From: Contact Centre (CRM) <contact@ribblevalley.gov.uk>
Sent: 12 December 2024 09:00
To: Planning
Subject: Planning Application Comments - 3/2024/0858 FS-Case-669978791

Planning Application Reference No.: 3/2024/0858

Address of Development: Backcastle Works, Pendle Court, Little Lane, Longridge, PR3 3WY

EXISTING (AS-BUILT) SITE PLAN

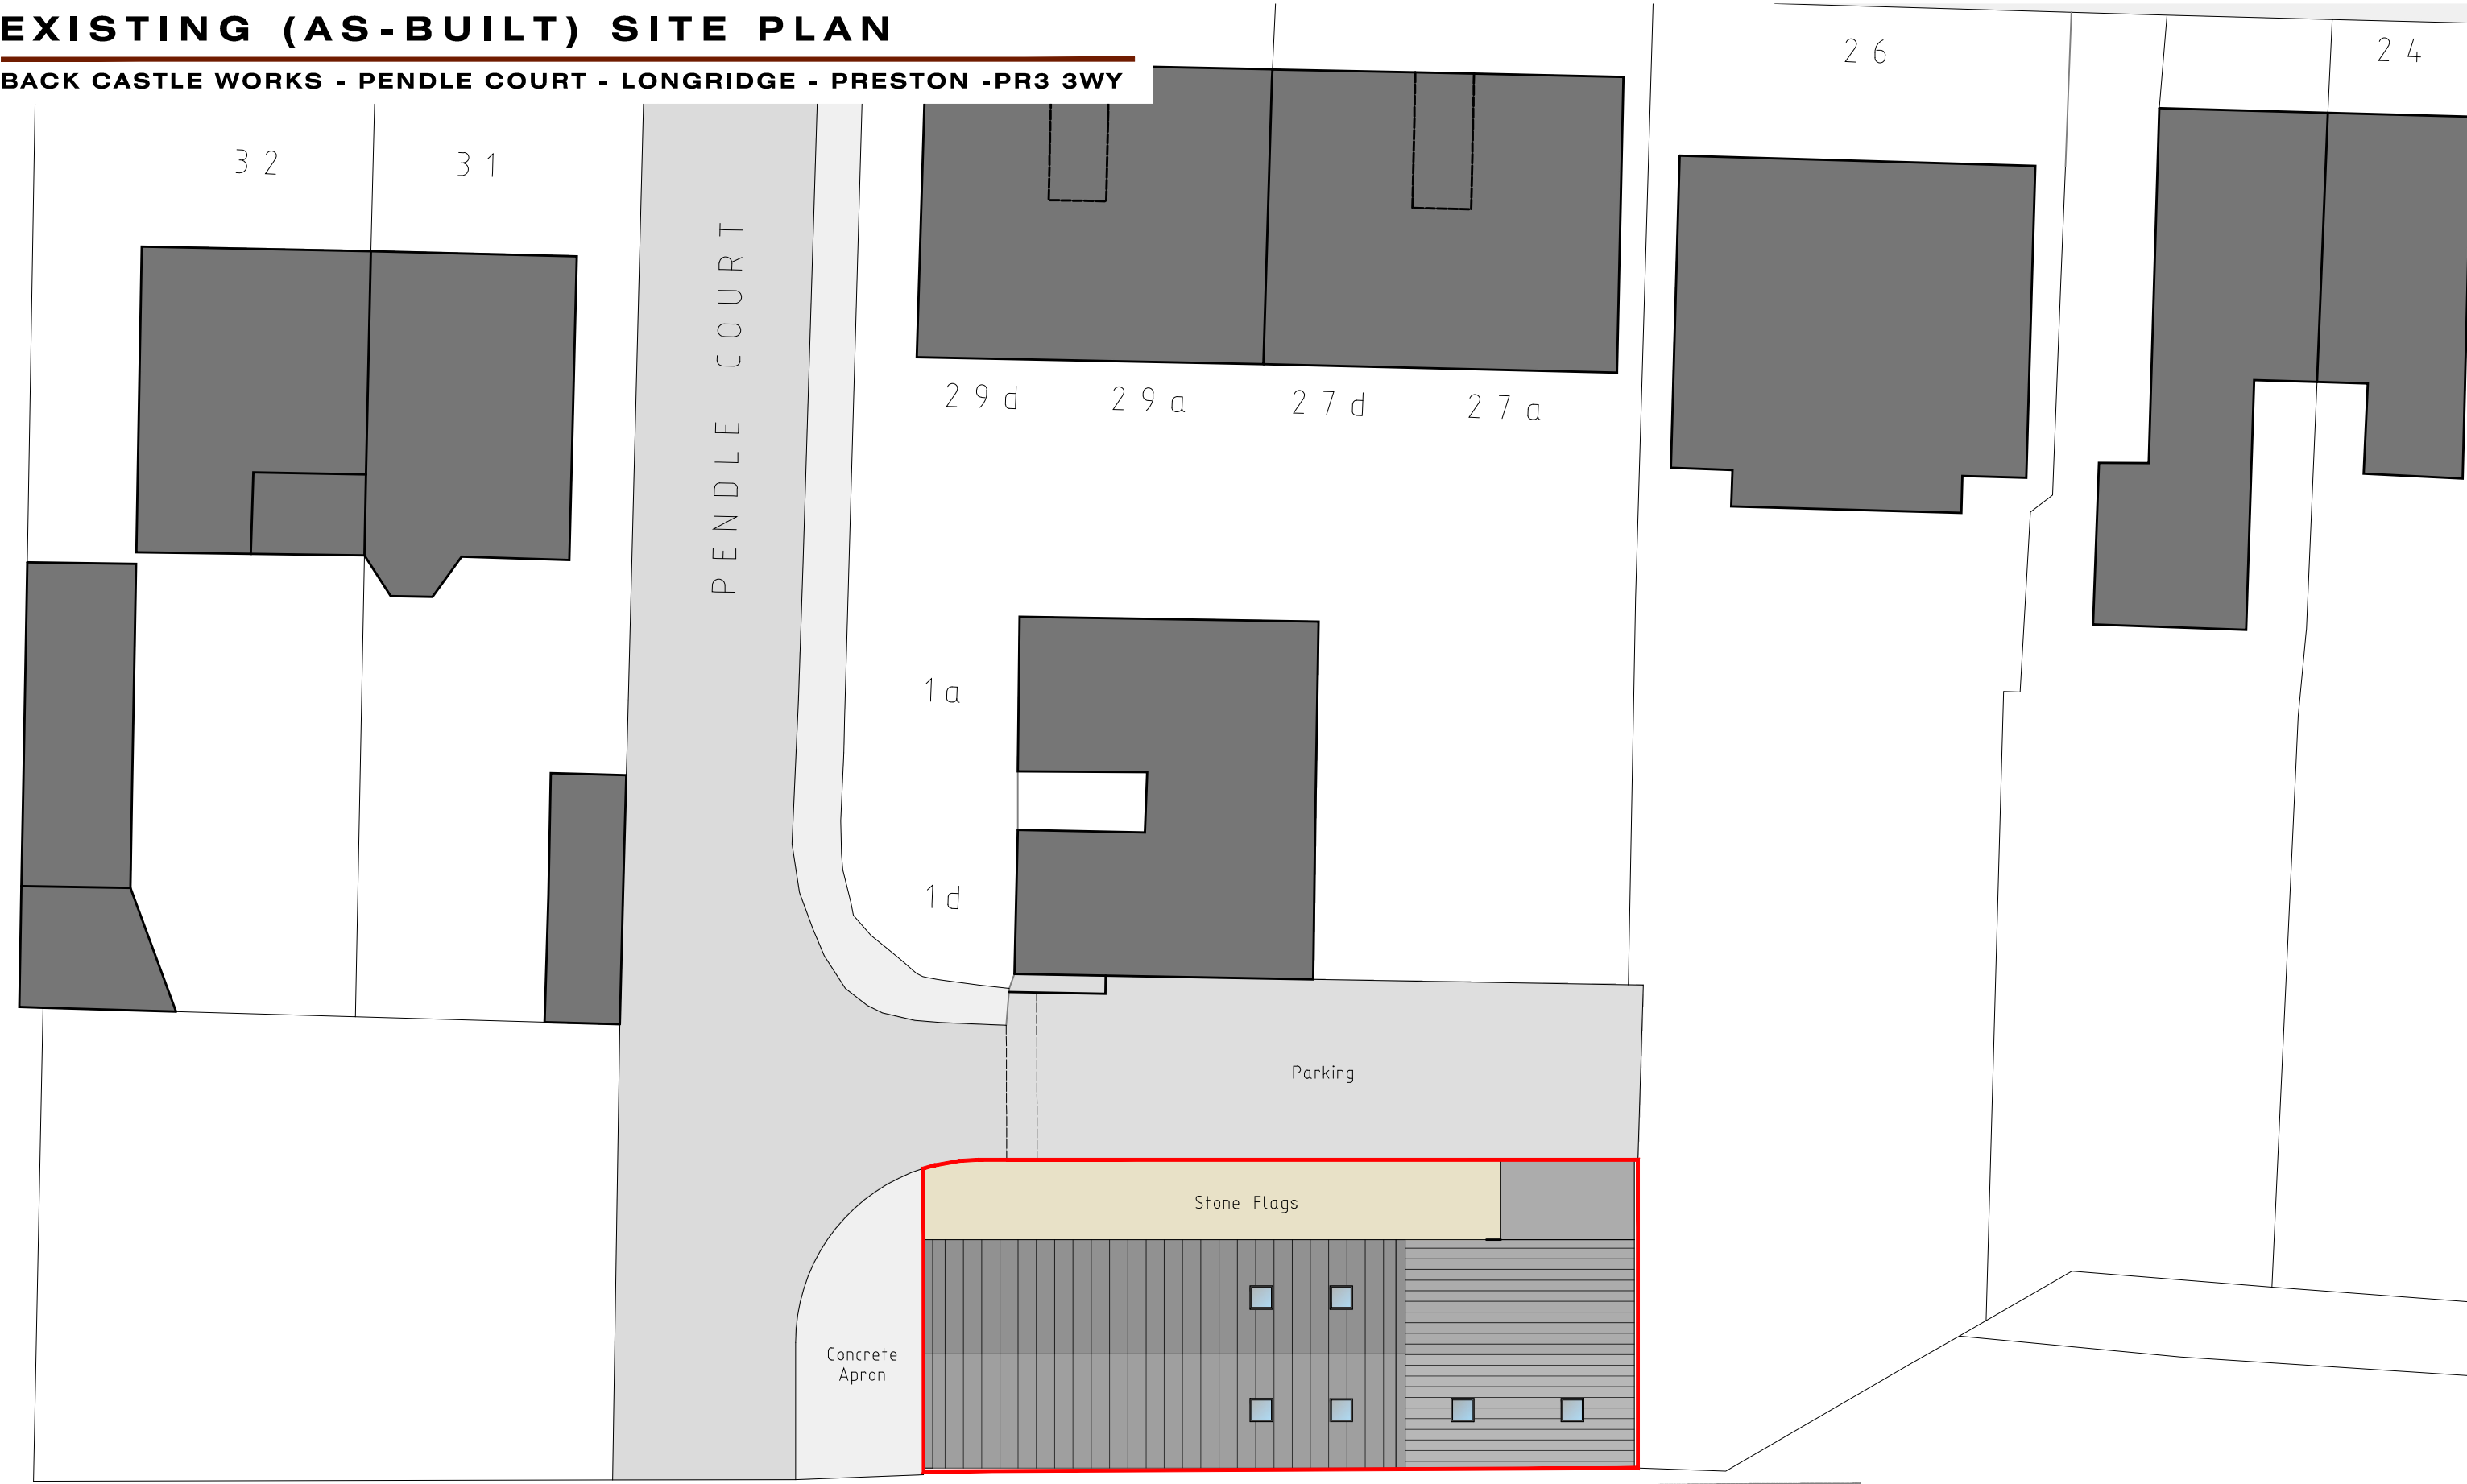
1. On the “Existing (As – Built) Site Plan”, the area of land between the red boundary of Back Castle Works and the gable end of the Pendle Court flat 1d is labelled on the application plan as “Parking”. We need to make it clear that this piece of land is entirely [REDACTED]. It does not belong to Back Castle Works. Please see Title Number [REDACTED] held at Land Registry. The users of Back Castle Works do have a right of way over this land, for loading and unloading purposes only, but in such cases for no longer than is reasonably necessary. There is No Parking available to the users of Back Castle Works on this land.
